CAMPBELL'S STORES

AMENDED DA ACCESS REVIEW

Morris Goding Accessibility Consulting

7 October 2016

Drawing Title  
**HICKSON ROAD LEVEL 01 PLAN**  
Drawing Number  
**12006**  
Drawing Status  
**EA**  
Drawing Number  
**EA-A-1002**  
Revision  
**B**

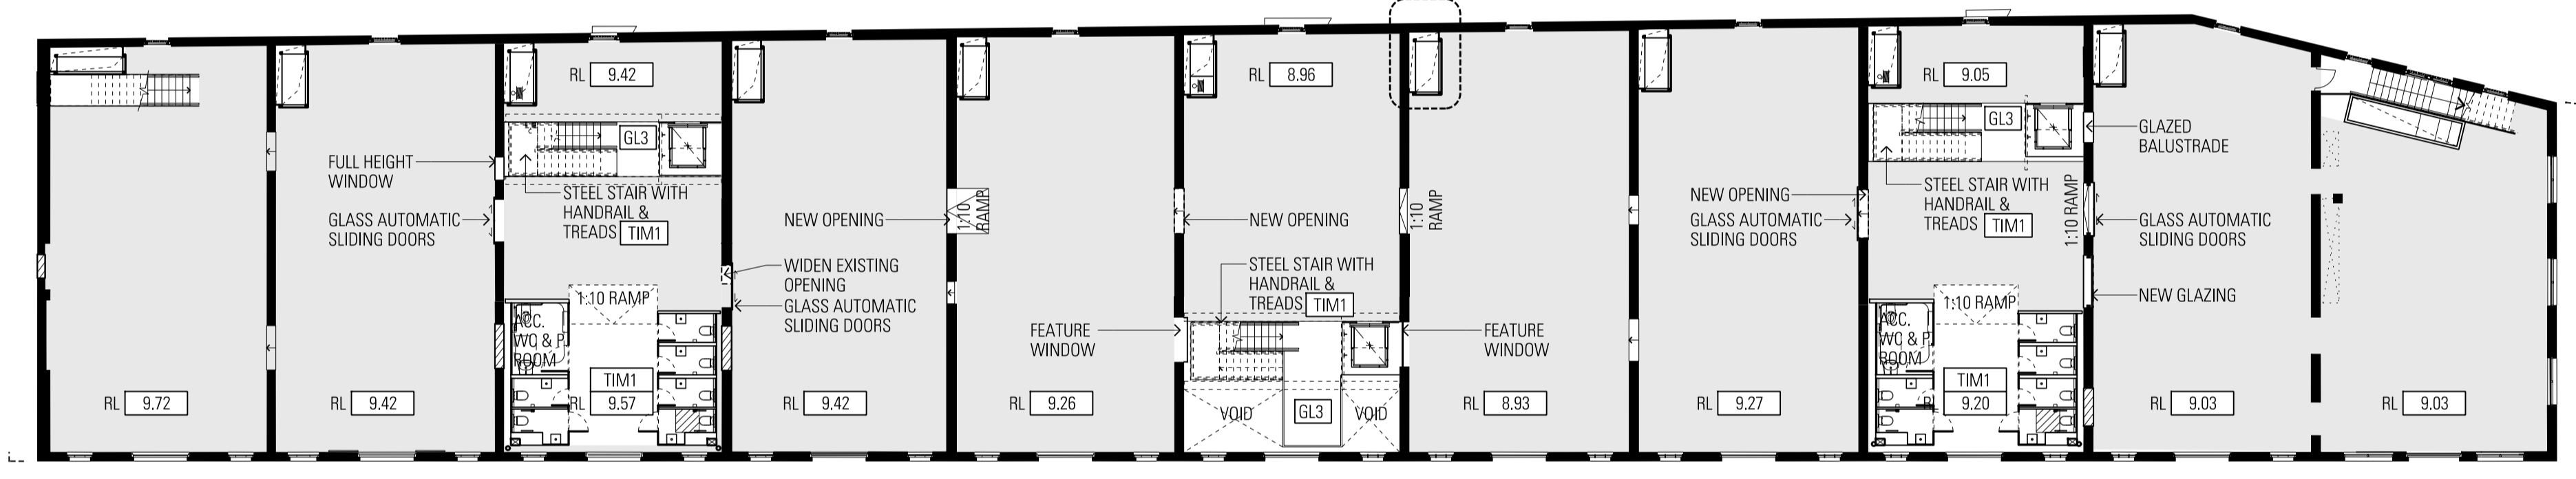
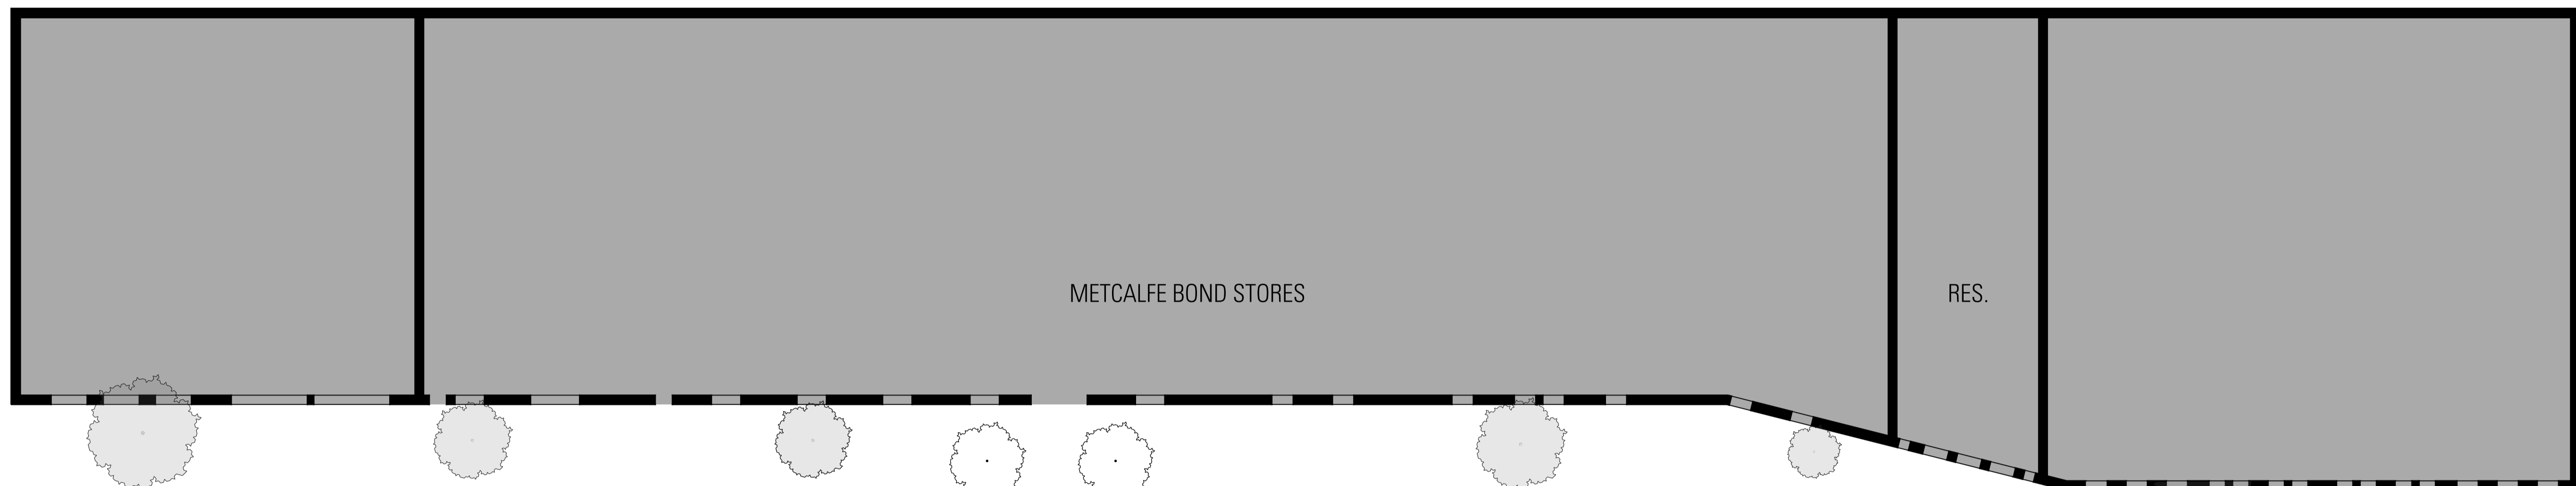
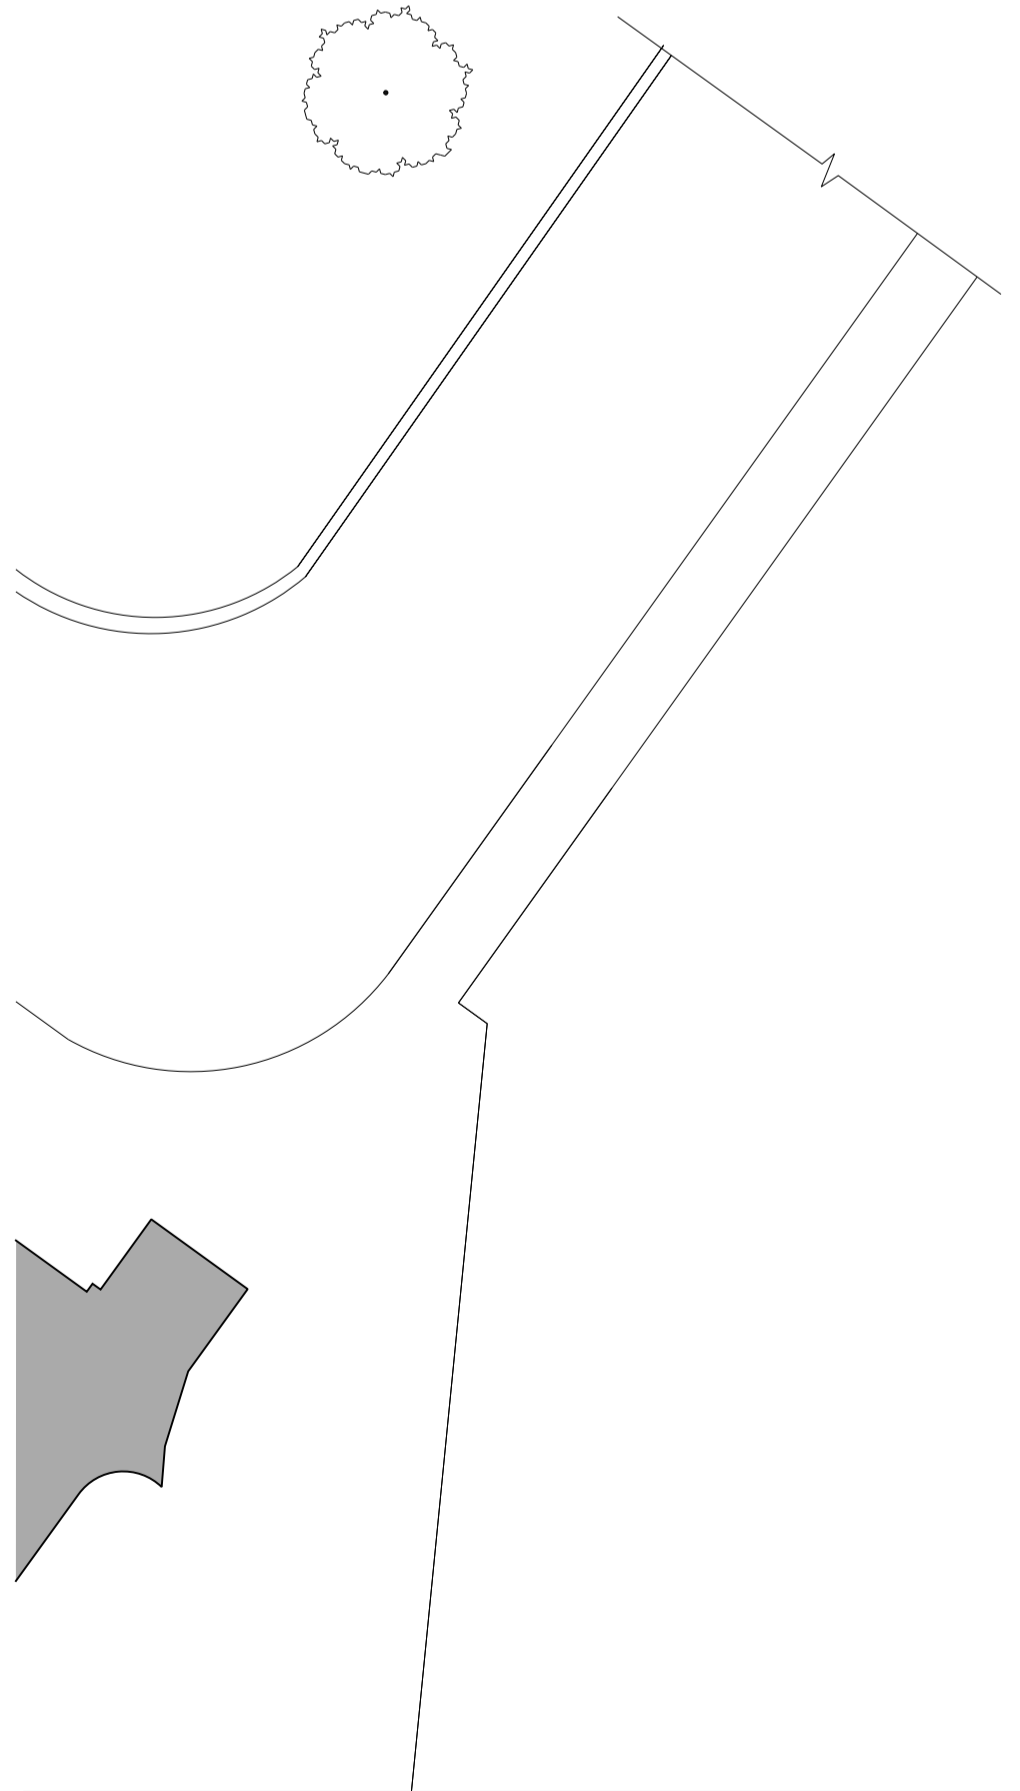
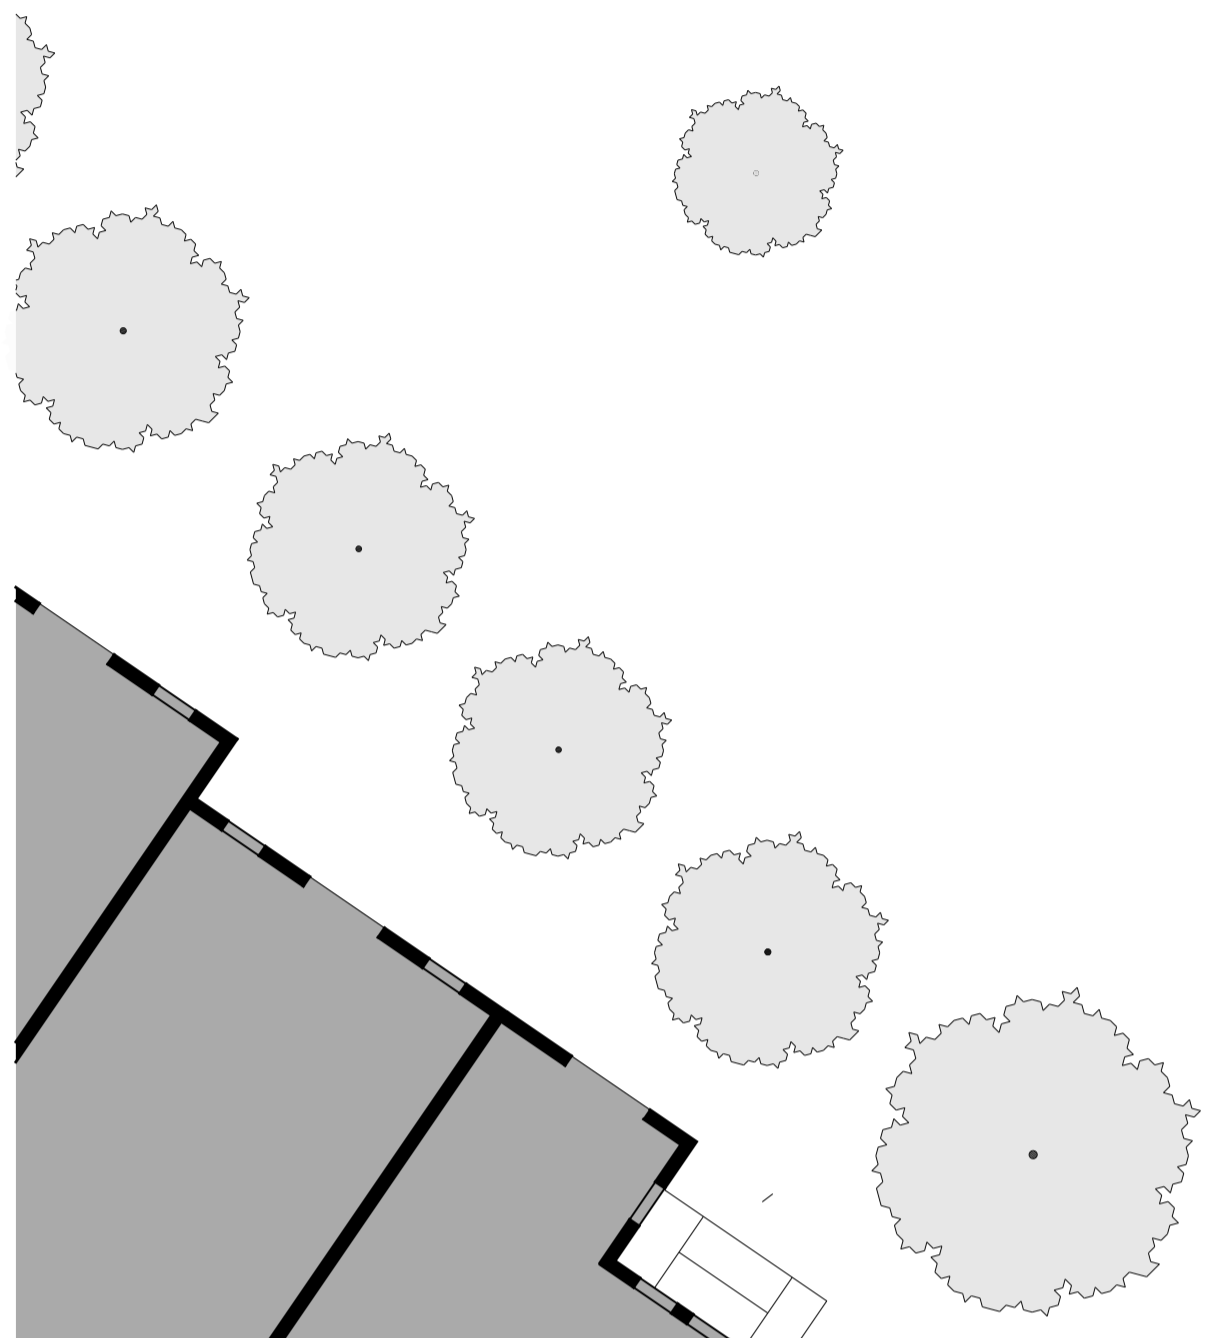
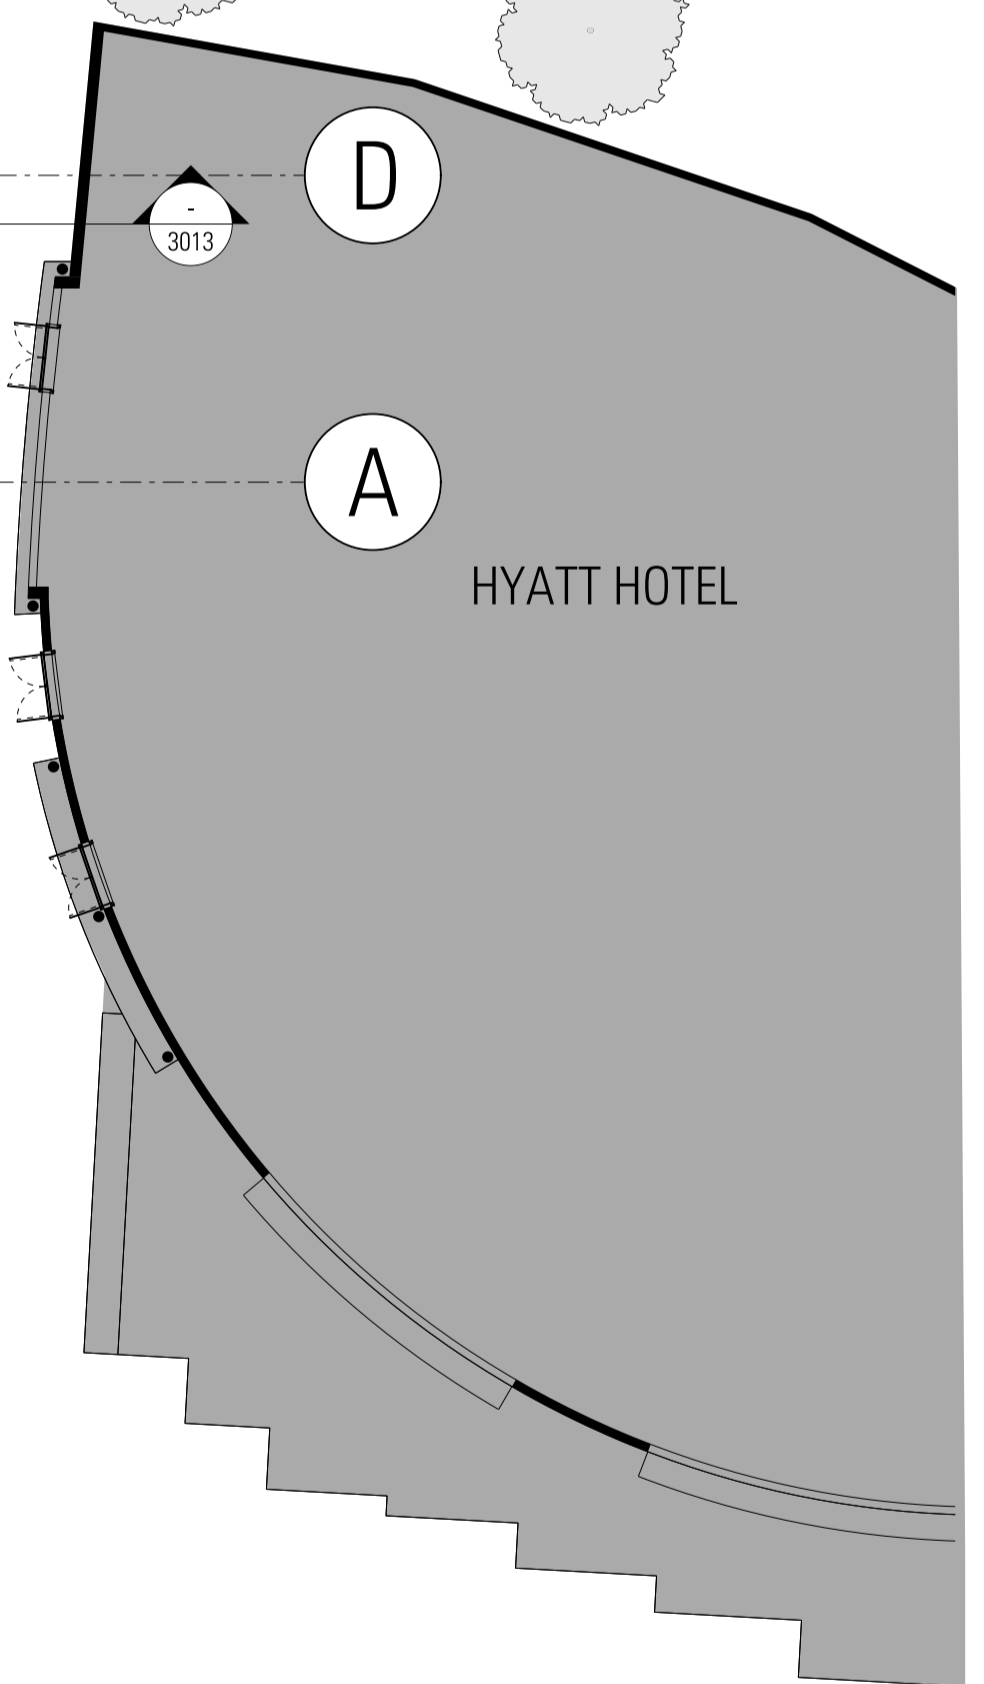
A new raised pedestrian crossing is indicated on western side of building opposite bay 5/6 with new kerbs proposed to provide improved pedestrian traffic and safety. Review will be required of the proposed surface to ensure accessibility for people with disabilities, compliant with AS1428.1.

The introduction of new tapered steps, facing Hickson Road seeks to increase the street frontage available and better connect the public footpath to the building surrounds. It is to be noted however that tapered stairs should be avoided where possible as they can be trip hazards and create issues for people with vision impairment.

- (i) Provide all new stairways with stair configuration and handrails on both sides of the stair, compliant with AS1428.1:2009. Note: stairs to be recessed by 900mm at base on site boundary so that handrail extensions and TGSIs are not located on public footpath/transverse paths of travel.
- (ii) Ensure new pedestrian crossing and connecting footpath linkages to accessible building entrances on Hickson Road are accessible to people with disabilities, compliant with AS1428.1:2009. Note: cobble paving surfaces are not generally compliant with AS1428.1 due to uneven surface profile variations and required spacing.

- (i) Ensure the threshold ramp or step ramp with landings at each required accessible tenancy main entry door is compliant with AS1428.1:2009. Note: exposed sides of ramps are to have a 45 degree splay for safety (transverse traffic) or be protected by a suitable side barrier.

- (i) Ensure the threshold ramp or step ramp with landings at each required accessible tenancy main entry door is compliant with AS1428.1:2009. Note: exposed sides of ramps are to have a 45 degree splay for safety (transverse traffic) or be protected by a suitable side barrier.

- (i) Ensure the new alternate entry doors level 01 to tenancy (bay 1, 11), are compliant with AS1428.1:2009
- (ii) As the new alternate entry at level 01 to tenancy (bay 1) outdoor area is not accessible from Hickson Road footpath, provide an alternate accessible internal route (via bay 1, 2) from Bay 3 Hickson Road main entrance/s, level 01.
- (iii) Ensure new alternate accessible entrance to building tenancy (bay 11), is accessible either via level access or an internal step ramp with landings to be developed at design development stage, to ensure compliance with AS1428.1:2009.
